An
Coimisiún
Pleanála

Inspector's Report

ACP-323433-25

Development	Section 146B request to alter the previously permitted replacement of existing biomass-fired boilers, biomass-fired thermal fluid heater and gas-fired thermal fluid heater at Medite's manufacturing plant (ABP-319013-24),
Location	Redmondstown, Clonmel, County Tipperary
Planning Authority	Tipperary County Council
Requester	Medite Europe DAC
Type of Application	Application under Section 146B of the Planning and Development Act, 2000 (as amended) to alter previously approved Strategic Infrastructure Development.
Date of Site Inspection	Not required
Inspector	Liam Bowe

Proposed Alterations Design
Development Area 2

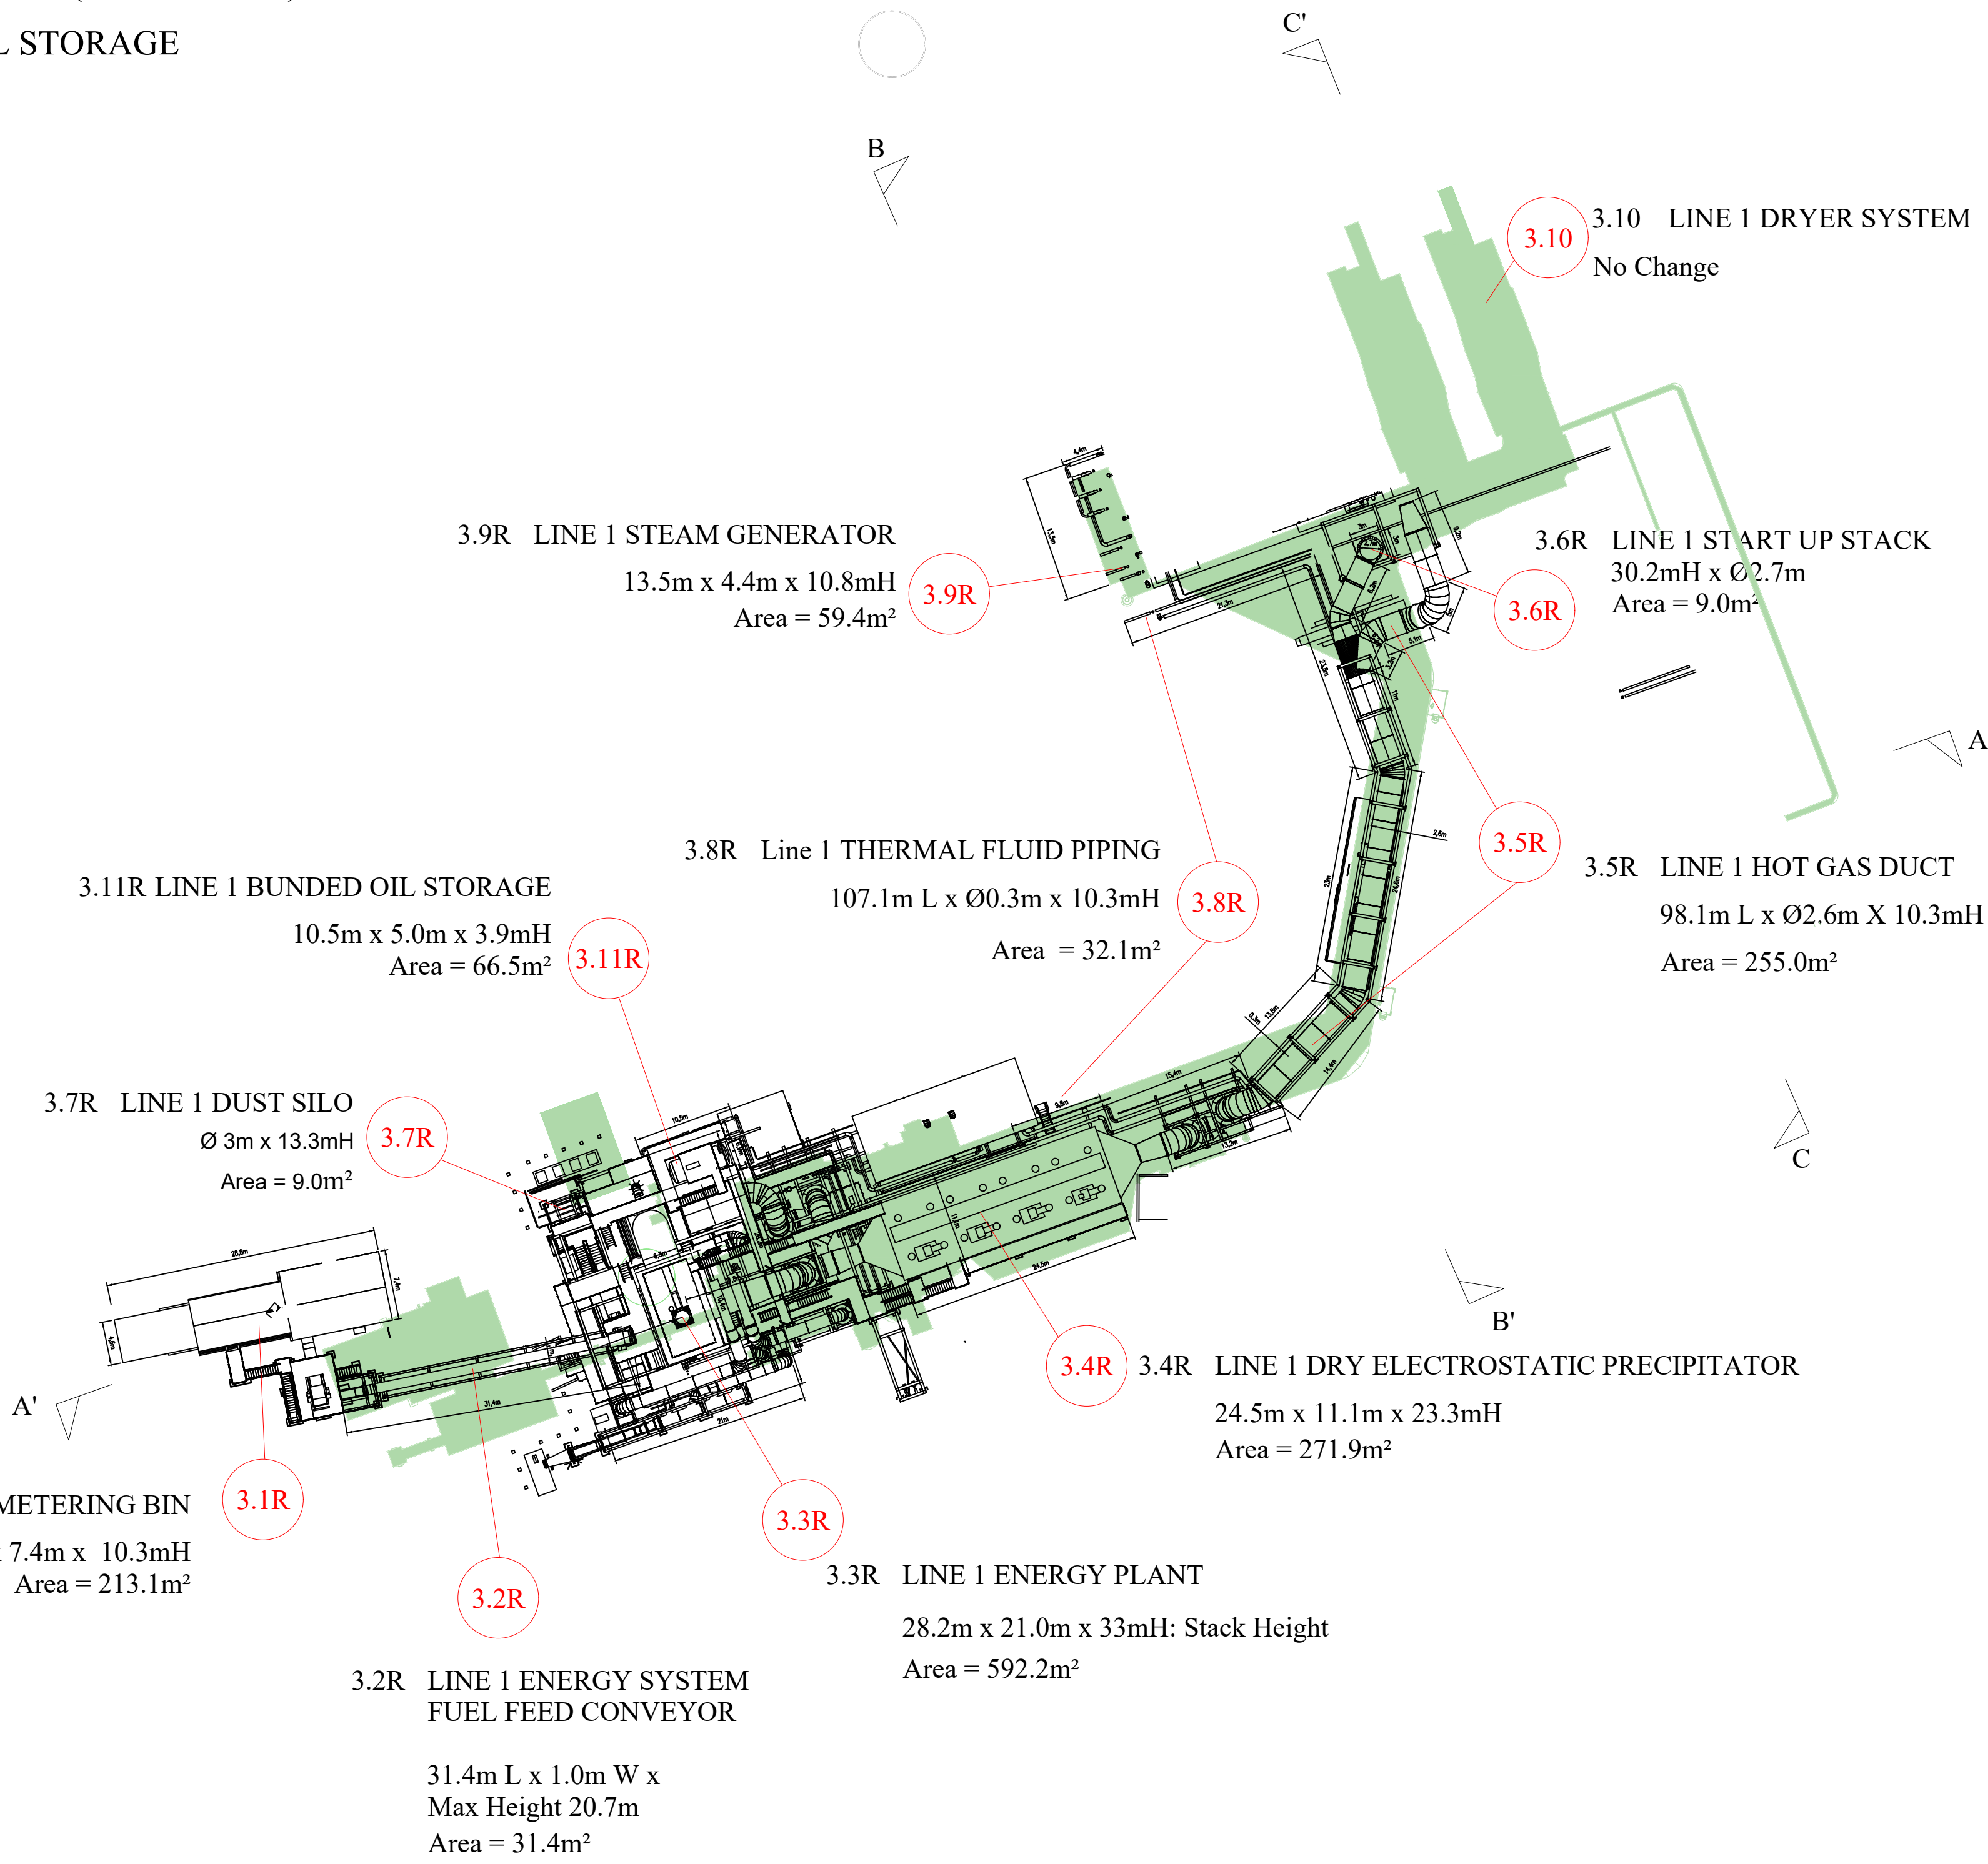
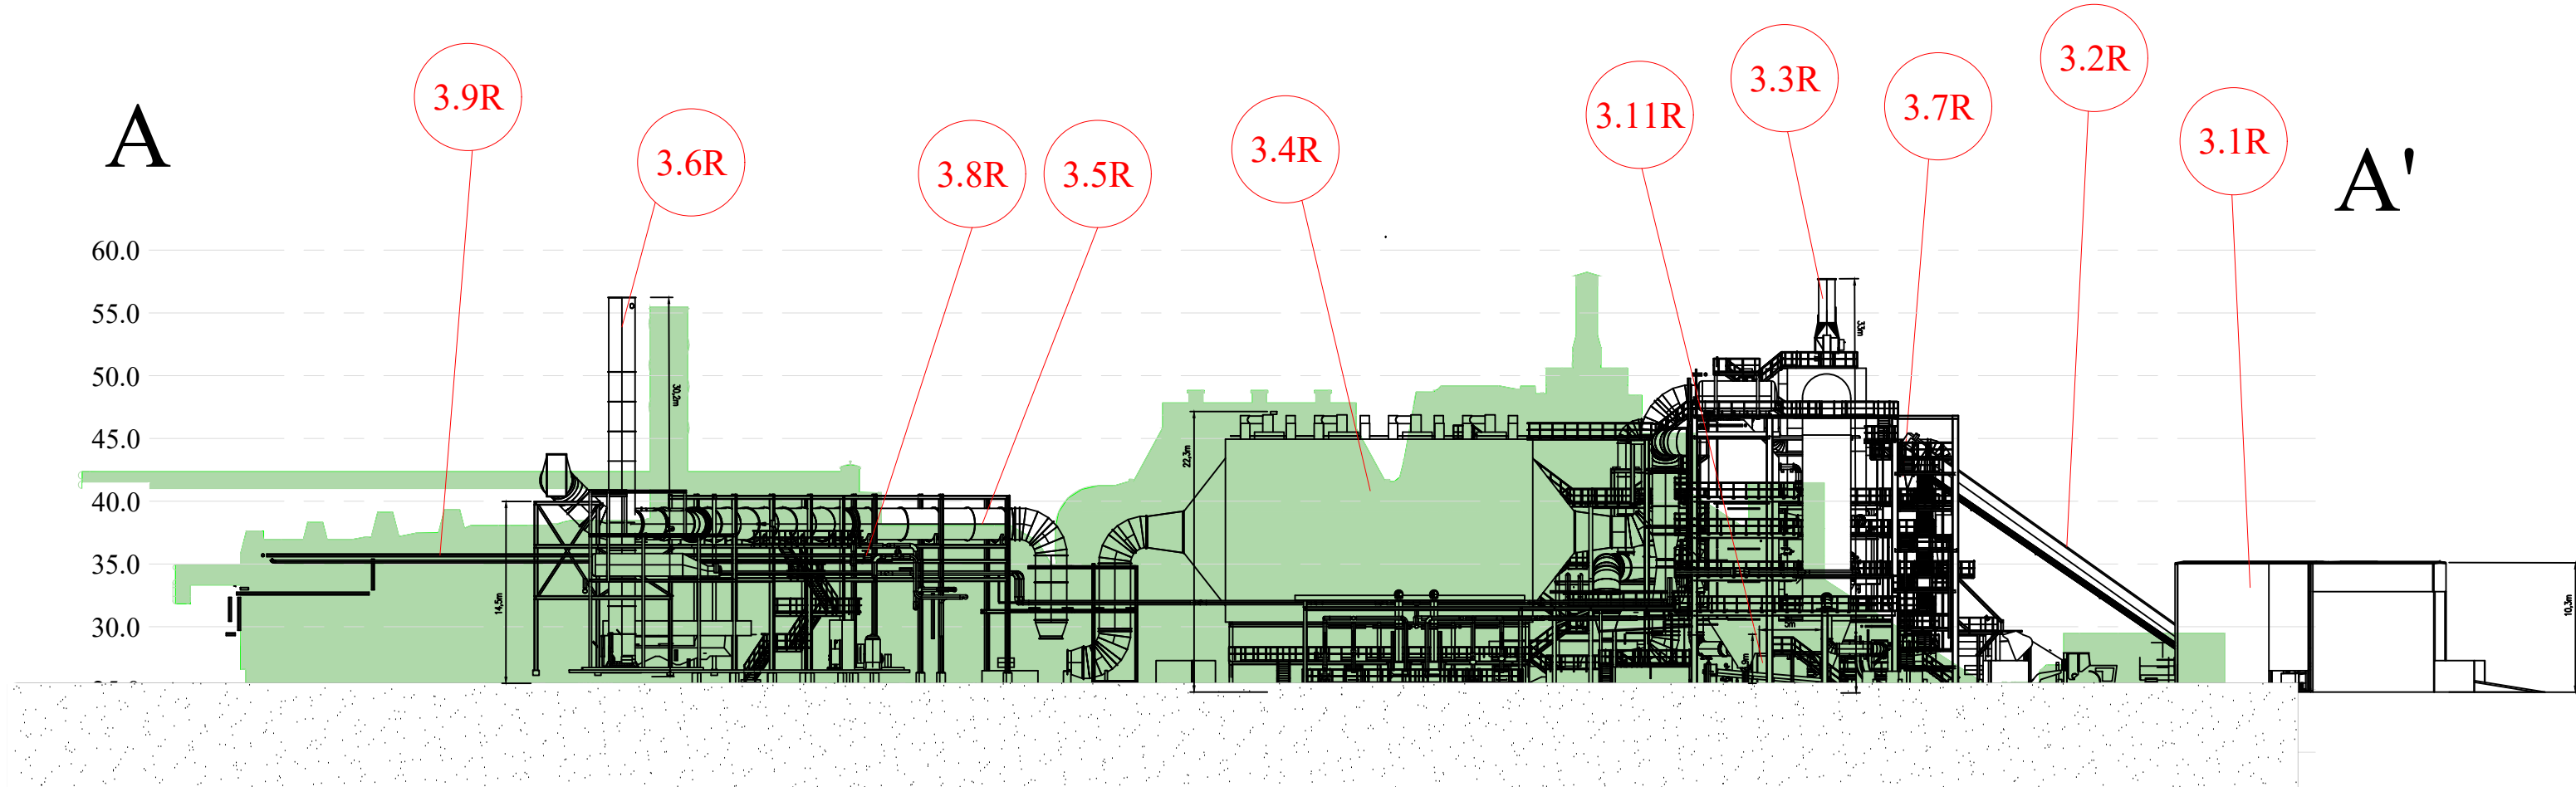
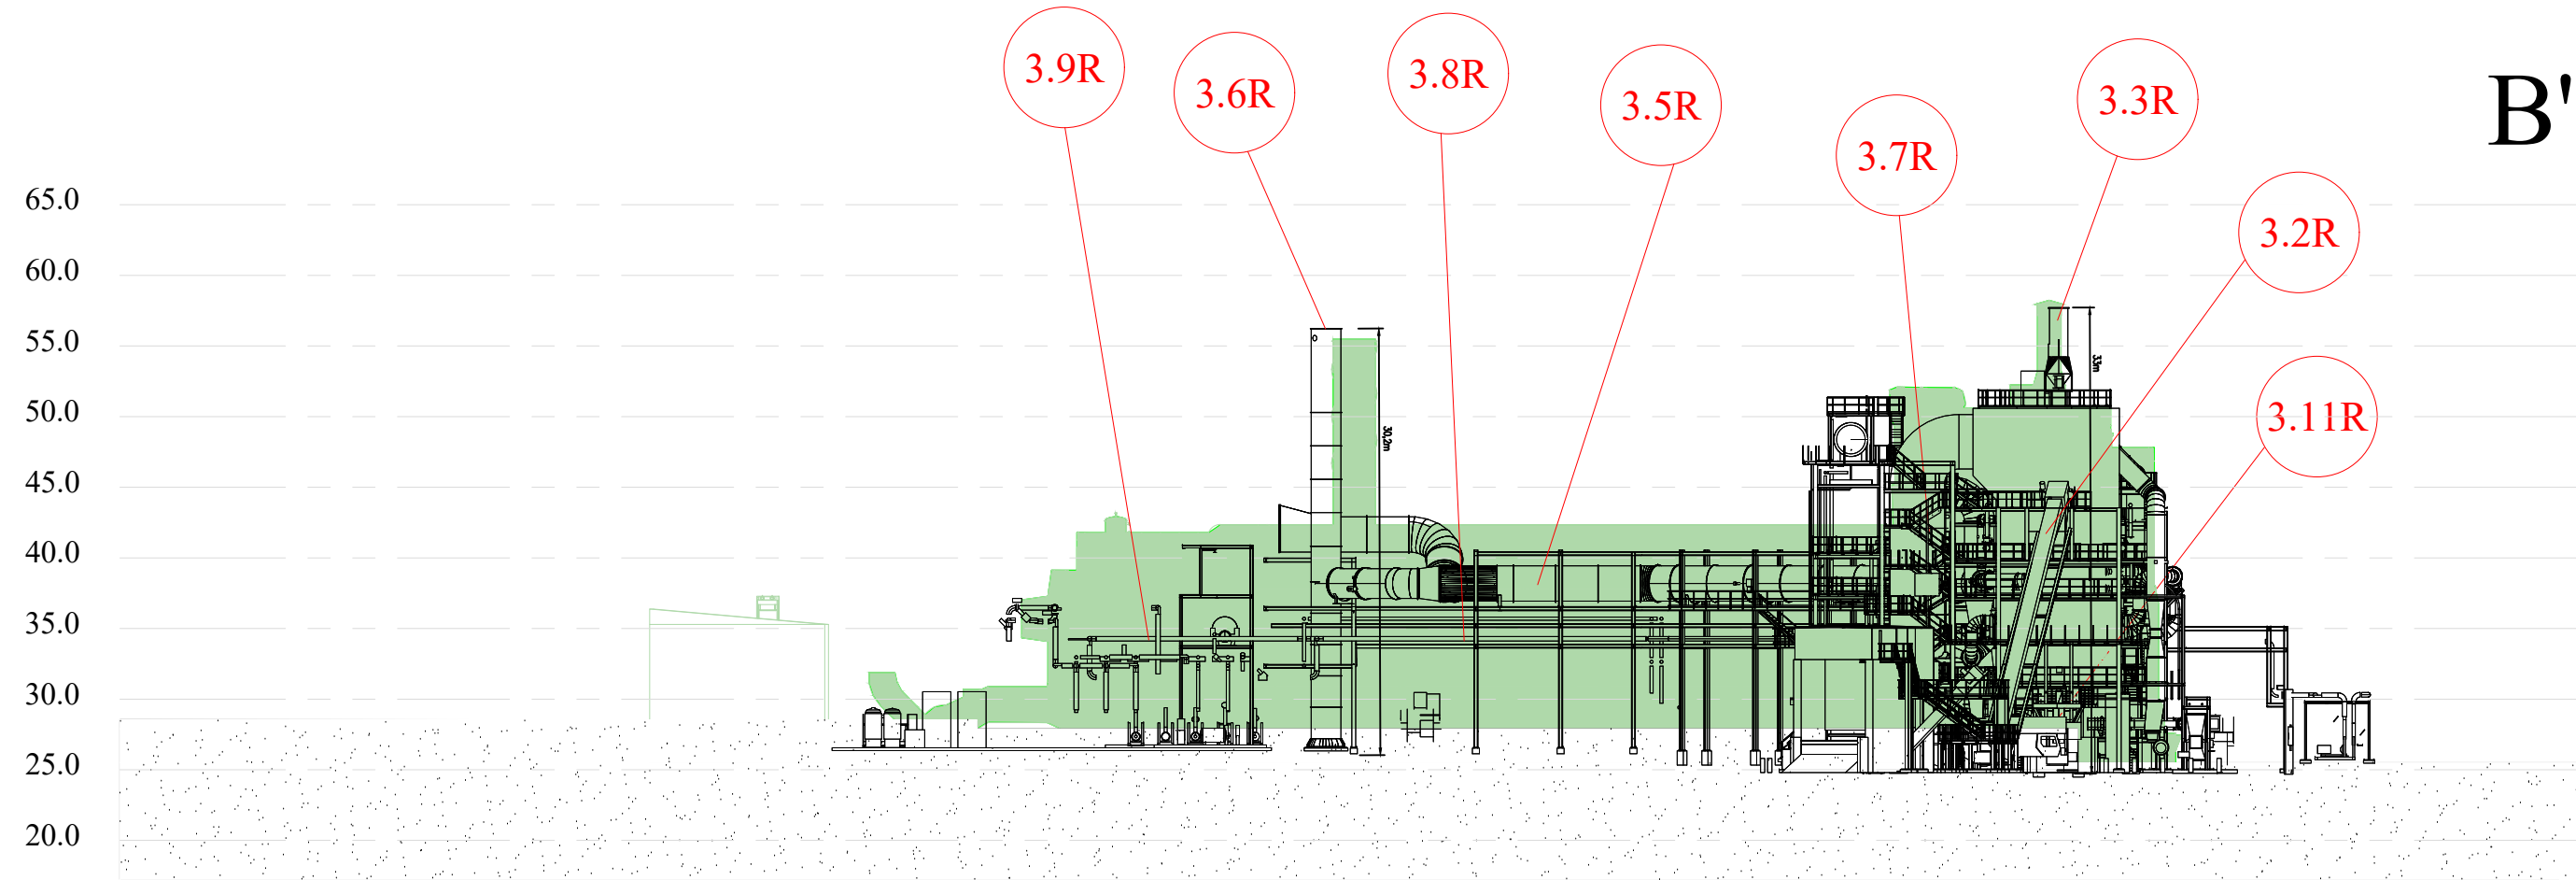
Table 2: Proposed alterations within Development Area 2

Item No.	Permitted Item	Proposed Item
3.1	Line 1 Wet Fuel Metering Bin 18.6m x 15.7m x 4.5mH Area = 292.0m ²	Line 1 Wet Fuel Metering Bin 28.8m 7.4m x 10.3mH Area = 213.1m ²

3.2	Line 1 Energy System Fuel Feed Conveyor 33.2m L x 1.1m W Max Height 17.8m Area = 38.0m ²	Line 1 Energy System Fuel Feed Conveyor 31.4m L x 1.0m W Max Height 20.7m Area: 31.4m ²

3.3	Line 1 Energy Plant 32.5m x 21.6m x 33m Area = 702m ²	Line 1 Energy Plant 28.2m x 21.0m x 33mH Area: 592.2m ²
3.4	Line 1 Dry Electrostatic Precipitator 27.6m x 13.7m x 23.3mH Area = 286.9 m ²	Line 1 Dry Electrostatic Precipitator 24.5m x 11.1m x 23.3mH Area = 271.9m ²

3.5	Line 1 Hot Gas Duct 105m long x Ø3.2m Area = 336.0m ²	Line 1 Hot Gas Duct 98.1m long x Ø2.6m Area: 255.0m ²
3.6	Line 1 Start Up Stack 30.2mH x Ø3.6m Area = 10.8m ²	Line 1 Start Up Stack 30.2mH x Ø2.7m Area: 9.0m ²

3.7	Line 1 Sander Dust Silo Ø 6.0m x 16mH Area = 28.3m ²	Line 1 Sander Dust Silo Ø 3.0m x 13.3mH Area: 9.0m ²
3.8	Line 1 Thermal Fluid Piping 217m L x Ø 0.6m x 16.3mH Area = 130.2 m ²	Line 1 Thermal Fluid Piping 107.1m L x Ø 0.3m x 10.3mH Area: 32.1 m ²

3.9	Line 1 Steam Generator 14.4m x 3.5m x 17.9mH Area = 47.5m ²	Line 1 Steam Generator 13.5m x 4.4m x 10.8mH Area: 59.4m ²
3.10	Line 1 Dryer System 34.0m x 17.5m x 13.9mH Area = 505.7m ²	Line 1 Dryer System 34.0m x 17.5m x 13.9mH Area = 505.7m ²
3.11	Line 1 Bunded Oil Storage 10.4m x 6.4m x 3.1mH Area = 66.5m ²	Line 1 Bunded Oil Storage 10.5m x 6.9m x 3.9mH Area: 72.5m ²
